LEGEND

GRADING DETAILS SHEET

EXTENDED DETENTION BASIN AS-BUILT
 DANE FRANK, TERRA NOVA ENGINEERING, 2025/03/13

COUNTY PRJ #: PPR-20-020
 EPC 11/29/21

INLET ORIFICE PLATE PERFORATED HOLE PATTERN NOT TO SCALE. THIS DETAIL IS FROM THE REV 1 PLANS

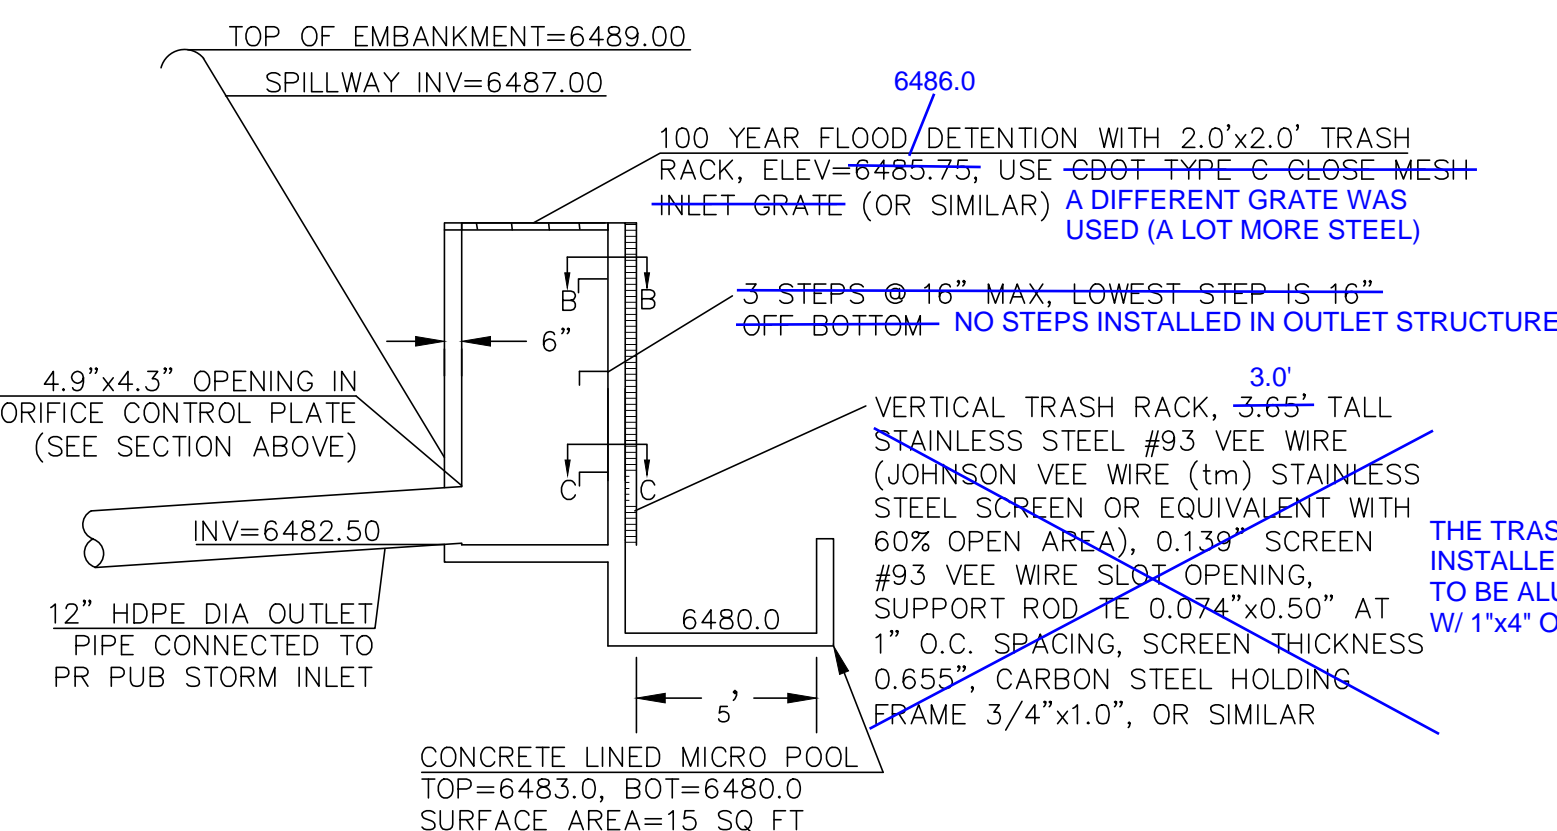
- THE BOTTOM ORIFICE ON THE INLET ORIFICE PLATE IS BUILT 0.2' HIGH. THE TOP TWO ORIFICES HAD TO BE REDRILLED AND THE CONTRACTOR LEFT THE BOTTOM ORIFICE HIGH DUE TO THE DESIGN ELEVATION HAVING TO GO THROUGH THE CONCRETE AND STEEL OF THE OUTLET STRUCTURE. THE BOTTOM ORIFICE WAS UPSIZED TO ADJUST FLOW FOR THE HIGHER ELEVATION. THE DESIGN SPREADSHEET SHOWS THIS ORIFICE LAYOUT CAUSES THE DRAIN TIMES TO BE: WQCV 40 HOURS, EURV 74 HOURS, 2 YEAR 64 HOURS, 5 YEAR 72 HOURS, 10 YEAR 77 HOURS, 25 YEAR 80 HOURS, 50 YEAR 79 HOURS, 100 YEAR 78 HOURS, AND 500 YEAR 77 HOURS. THE POND IS SHOWN TO STILL HAVE ADEQUATE STORAGE CAPACITY AND FREEBOARD IN THIS CONDITION.

OUTLET STRUCTURE NOT TO SCALE

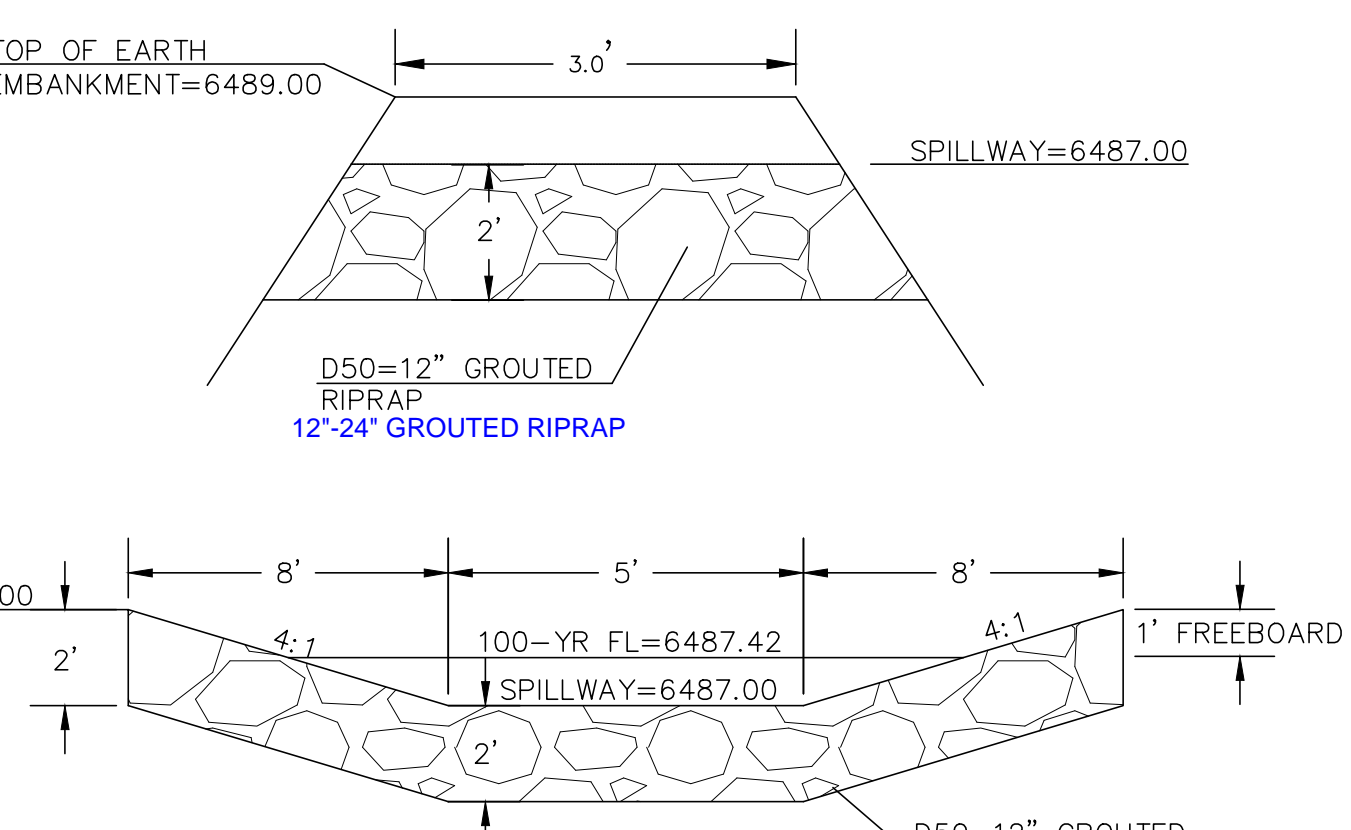
- AS-BUILT REDLINES ARE SHOWN IN BLUE.
- THE FINAL GRADING WAS A LITTLE DIFFERENT THAN THE DESIGN, AND THE TOP OF THE OUTLET STRUCTURE WAS BUILT 6" HIGH. CHECKING THE AS-BUILT NUMBERS WITH THE DESIGN SPREADSHEET SHOWS THE GRADING AND OUTLET STRUCTURE TOP WILL FUNCTION AS INTENDED, WITH THE WATER SURFACE ELEVATIONS CHANGING A LITTLE.
